Our ref: UNSW G25 Education Building (SSD-74670005)

## Subject: UNSW G25 Education Building (SSD-74670005) - Response to Submissions

## Attachment A

4.a Pursue opportunities to consolidate the separated pathway and planned shared roadway through providing consistent materiality.

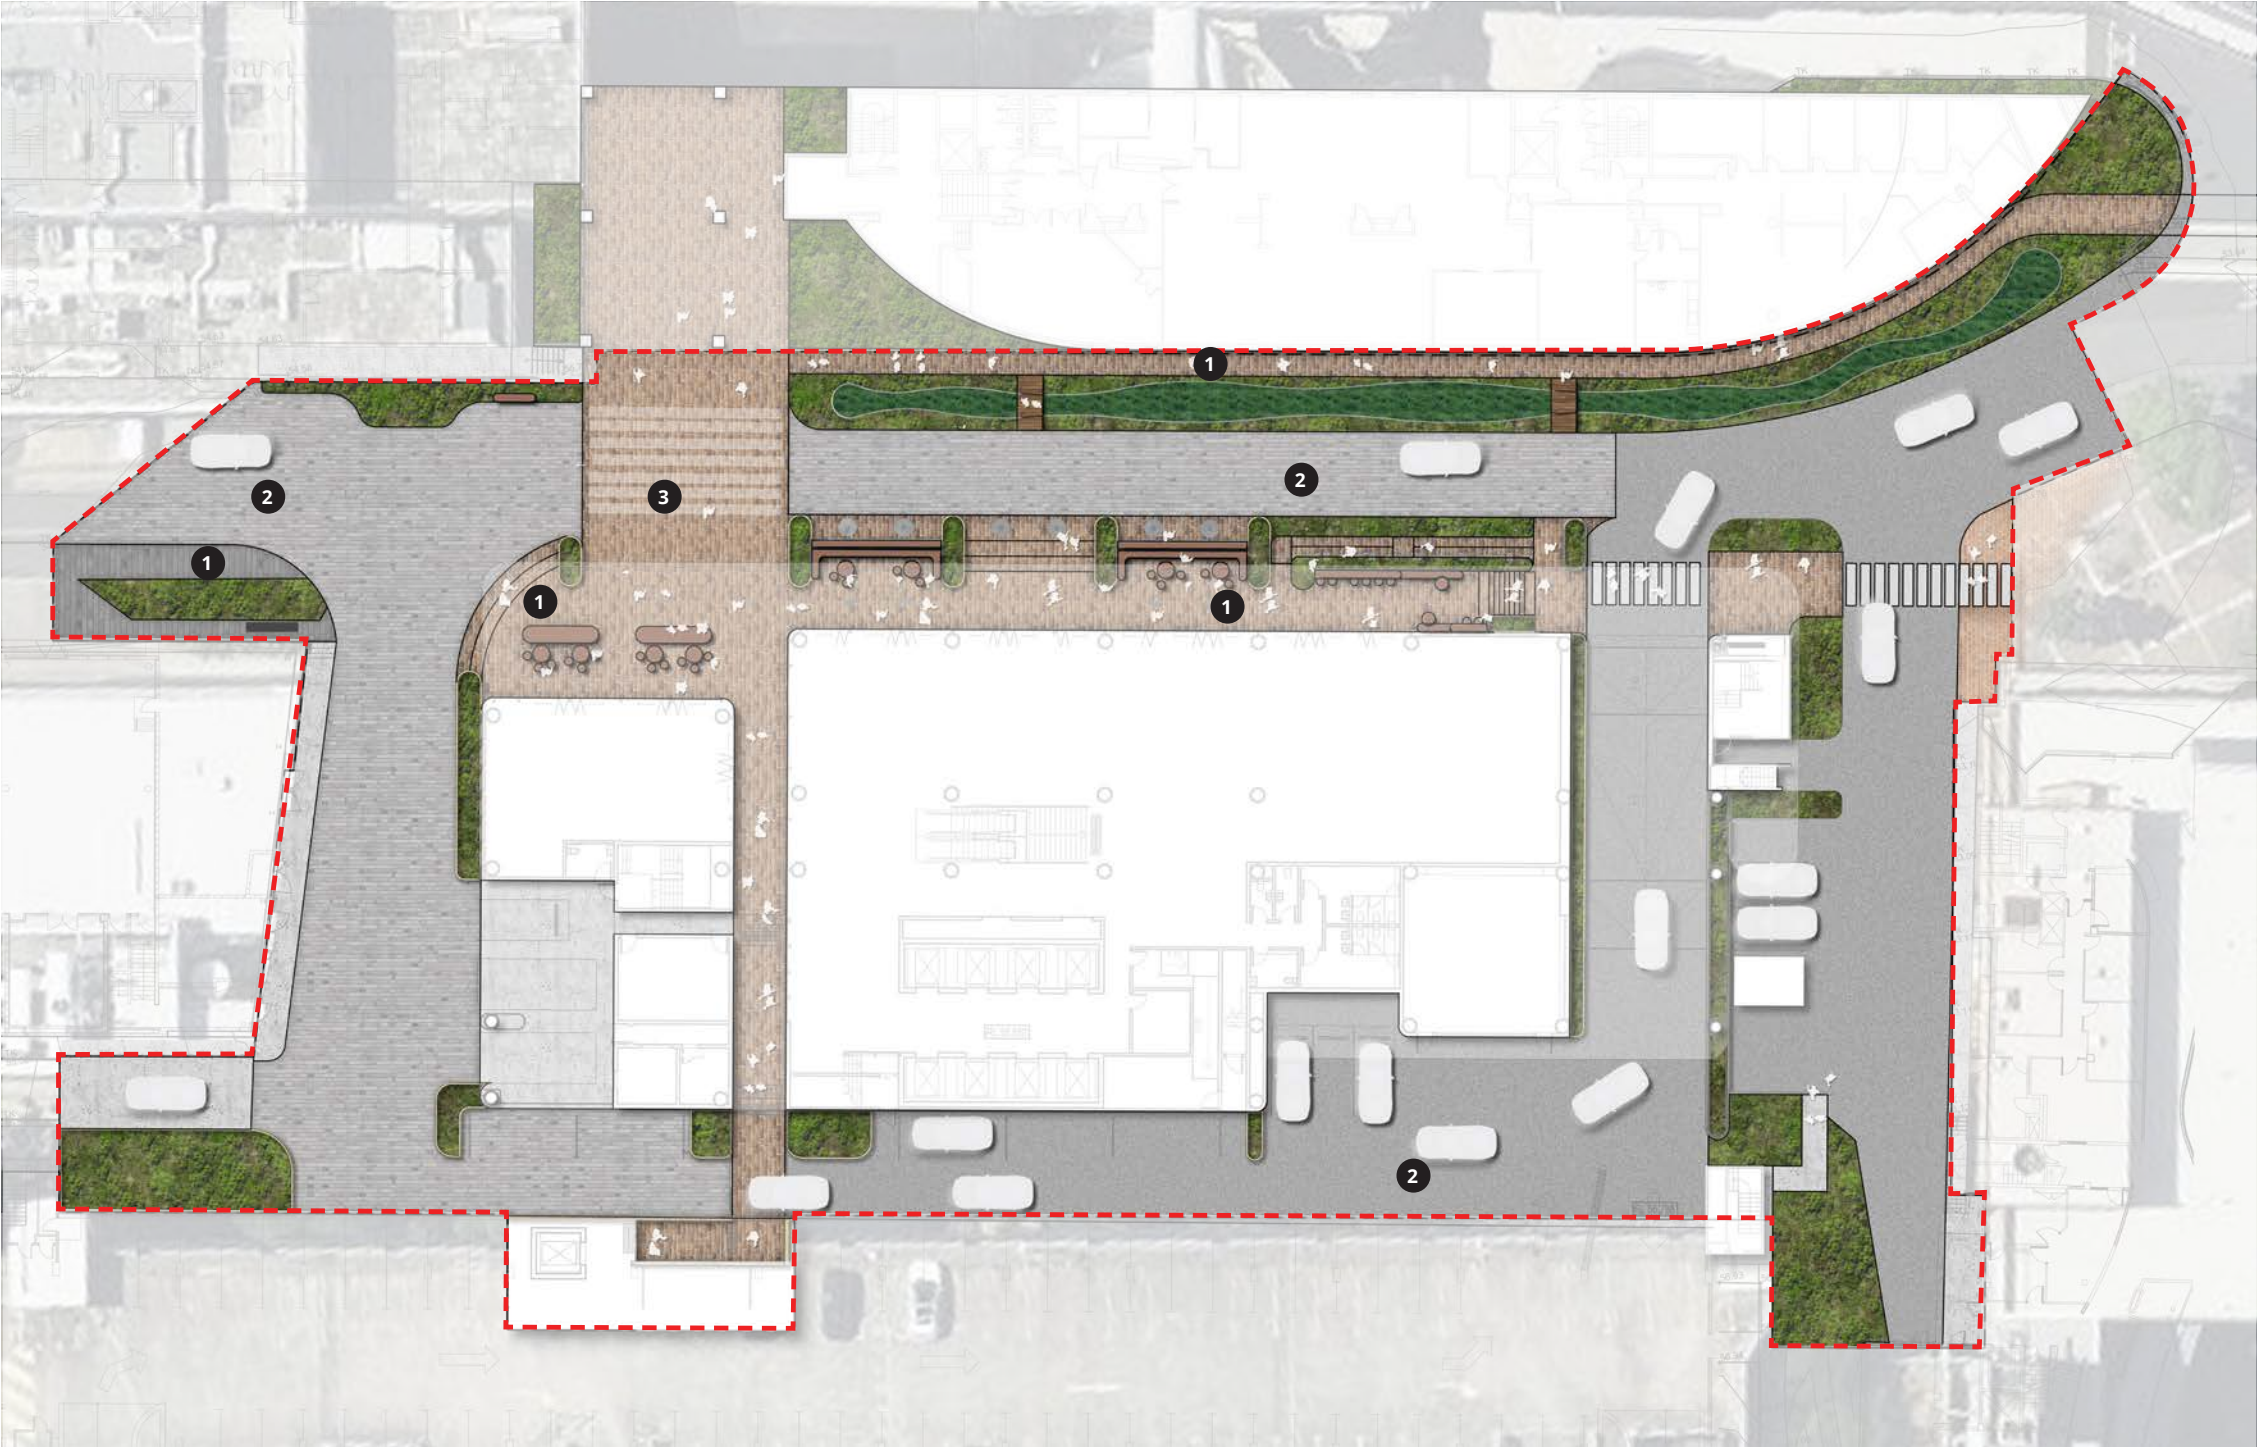
- Provide details of materials to be used for the informal connections between boardwalk and shared way and how that addresses State Design Review Panel comments. Provide updated landscape drawings to clearly identify material selection.

Figure 4 Approved Part 5 demolition works (in blue) and SSD demolition works (in red)

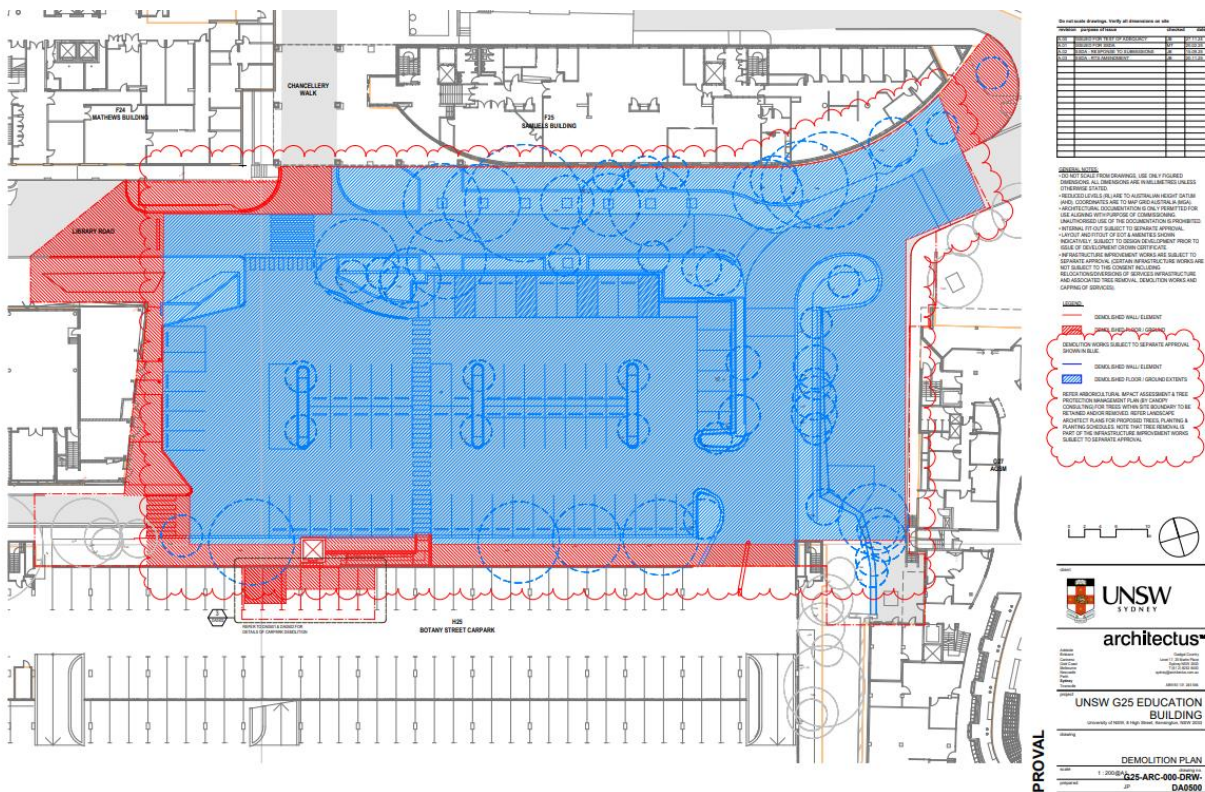
- The EIS identifies varying numbers for spaces to be removed in the existing multi-level carpark. Confirm car parking removal numbers and provide demolition plans for all levels where demolition works are proposed for the multi-level carpark.
